From: Laura Gibbons <Laura.Gibbons@arun.gov.uk>
Sent: 08 February 2022 10:00
To: Planning.Responses <Planning.Responses@arun.gov.uk>
Cc: Simon Davis <Simon.Davis@arun.gov.uk>
Subject: RE: Planning Re-Consultation on: Y/184/21/DOC

Engineers Comments Regarding Condition 8

Application No: Y/184/21/DOC
Registered: 7th January 2022
Site Address: 10 Acre Field Grevatts Lane West Yapton Bognor
Grid Reference: 498000 101780
Category: Discharge of Condi
Description of Works: Approval of details reserved by condition imposed under ref W/4000394 (Y/103/18/PL) relating to Condition Nos 5 - Construction & Environmental Management Plan, 8 - surface water drainage, 9 - discharge flows to watercourses, 10 - maintenance & management of surface water drainage, 12 - monitoring regime, 13 - landscaping, 14 - materials & finishes, 15 - landscape management plan and 20 - external lighting.

I am able to inform you that I have received an amendment to the above application dated 26th January 2022 relating to: Response to Drainage Concerns inc revised drainage plans & other new supporting plans

Proposed Foul and Surface Water Drainage Layout

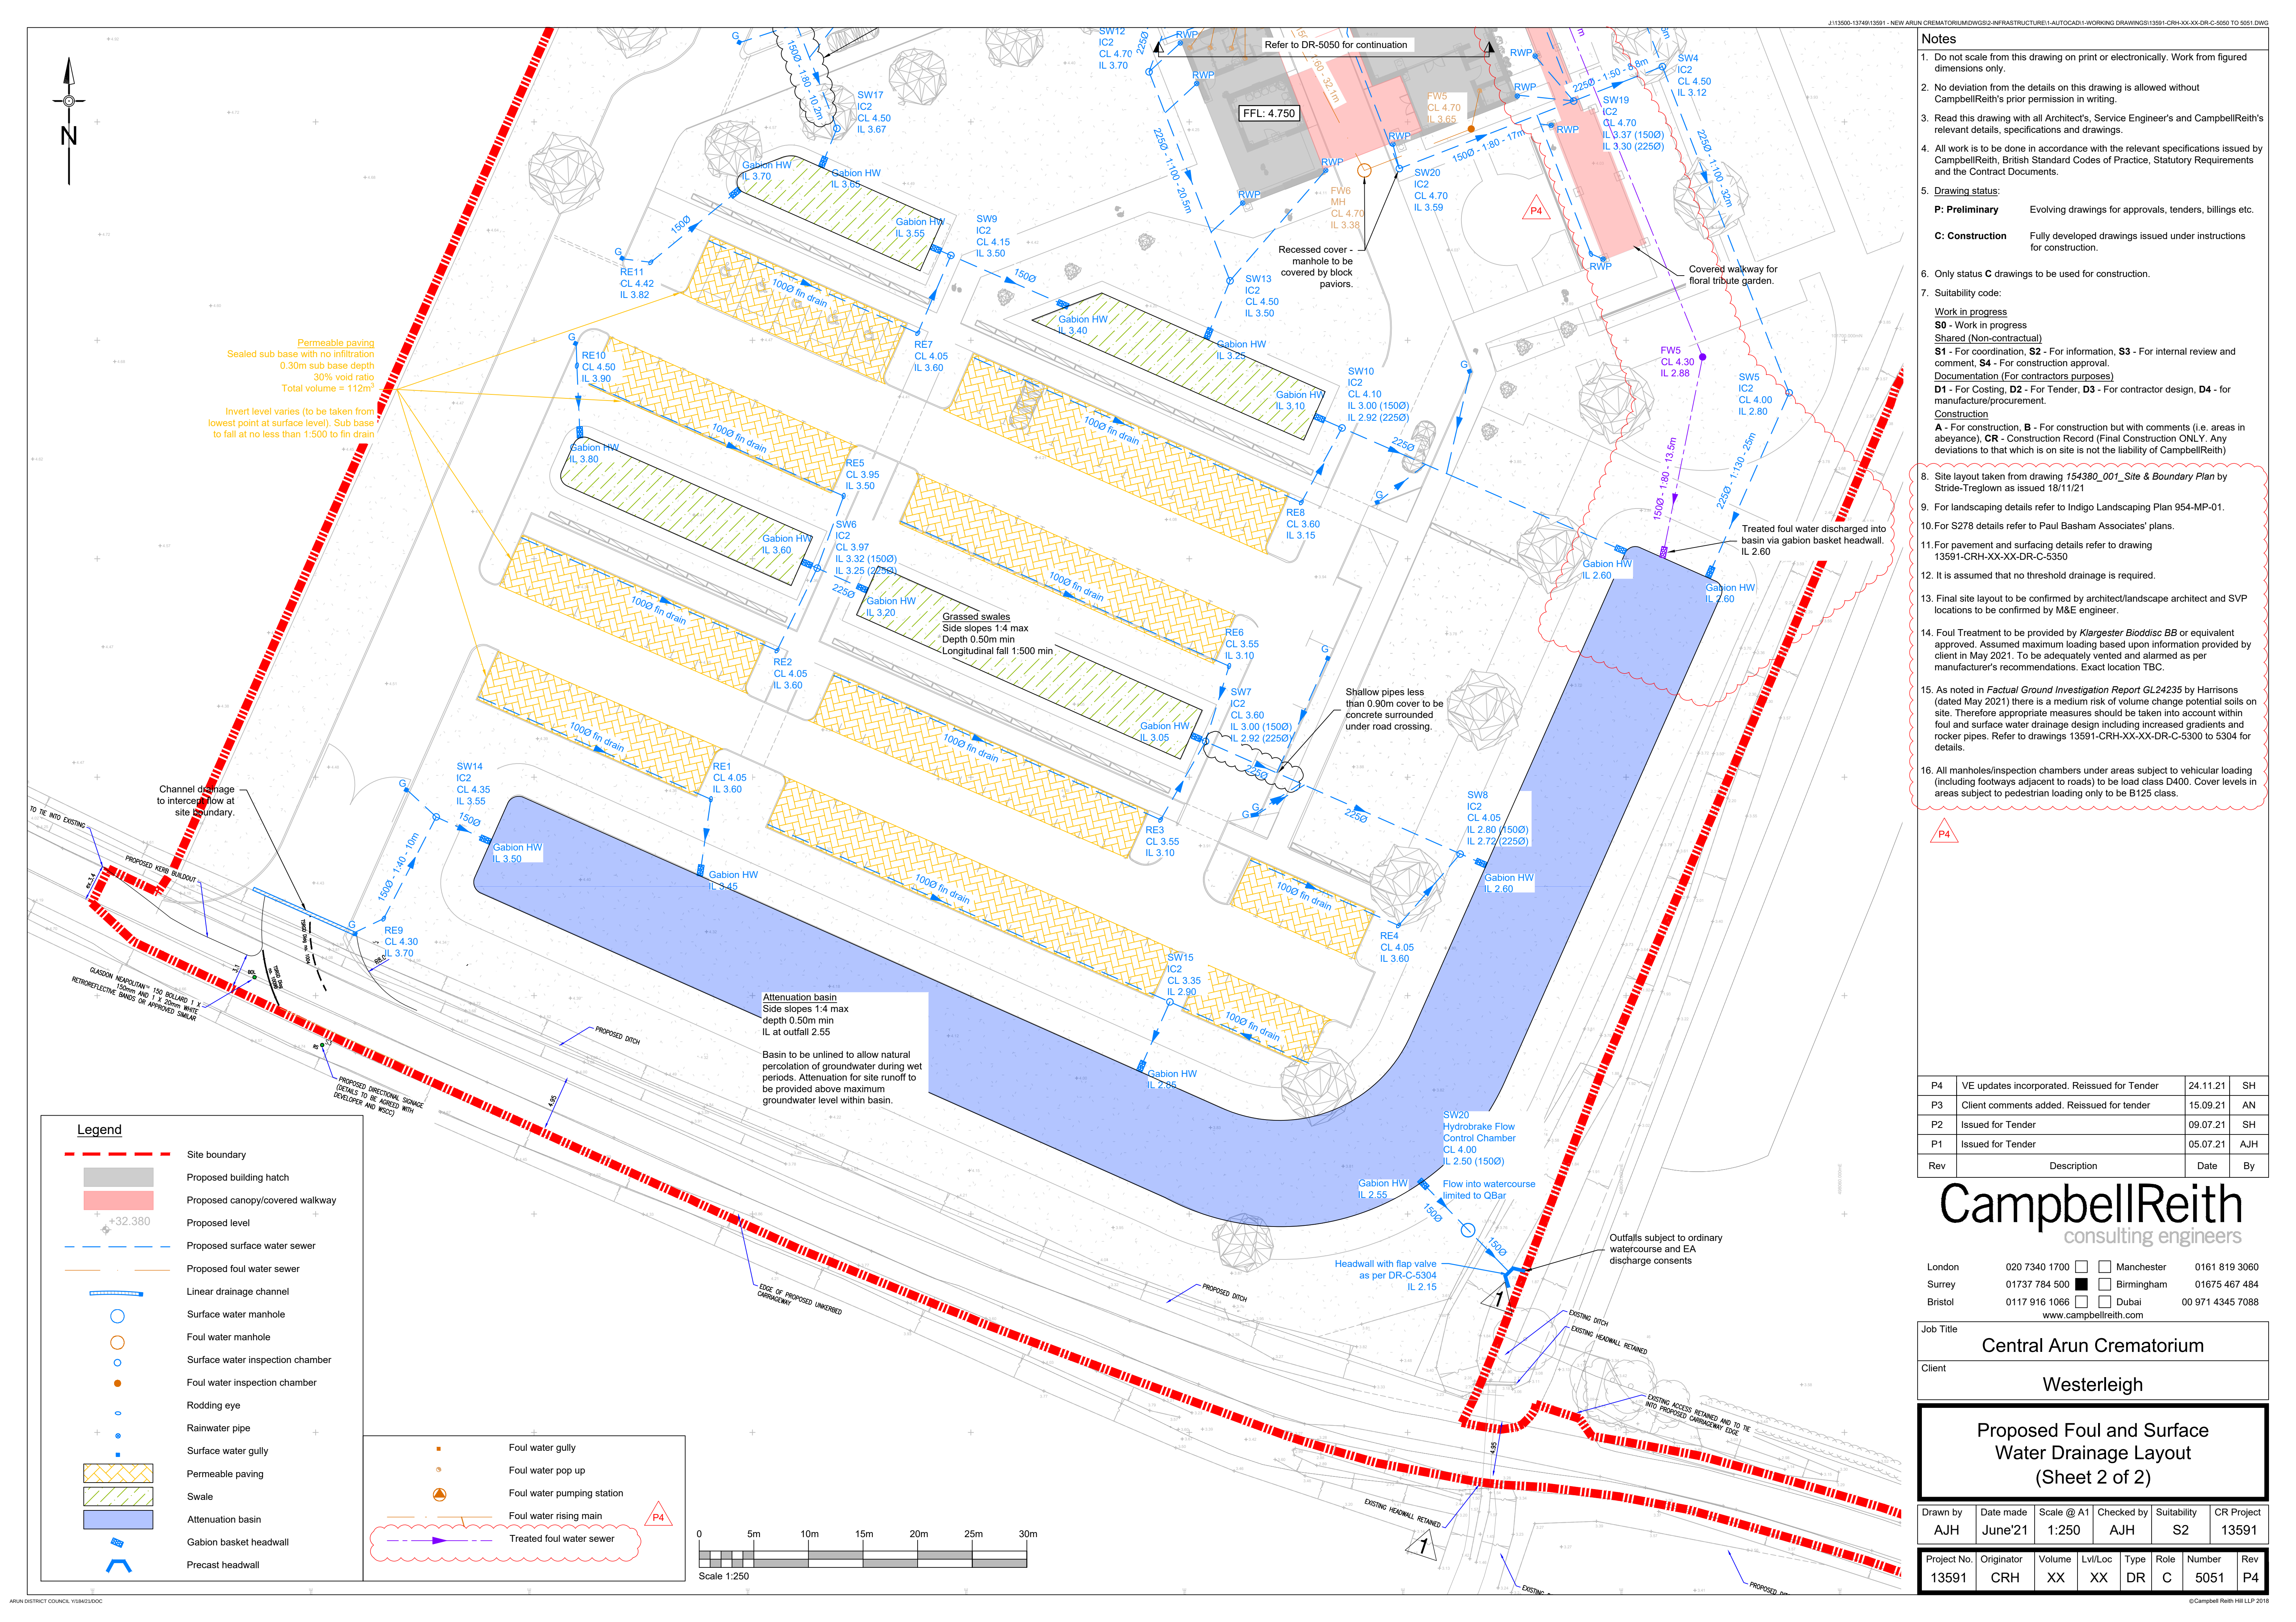
As per WSCC policy for the management of surface water policy 1- design must follow the hierarchy for sustainable drainage. Locations of groundwater monitoring and infiltration testing have not been provided. It is noted that groundwater was found to peak at circa 1m depth. Shallow infiltration testing was completed and gave rates which do not preclude the use of infiltration. Please supply evidence why the sole use of infiltration is not acceptable here. E.g. a design with infiltrating permeable paving, swales and shallow infiltration basin.
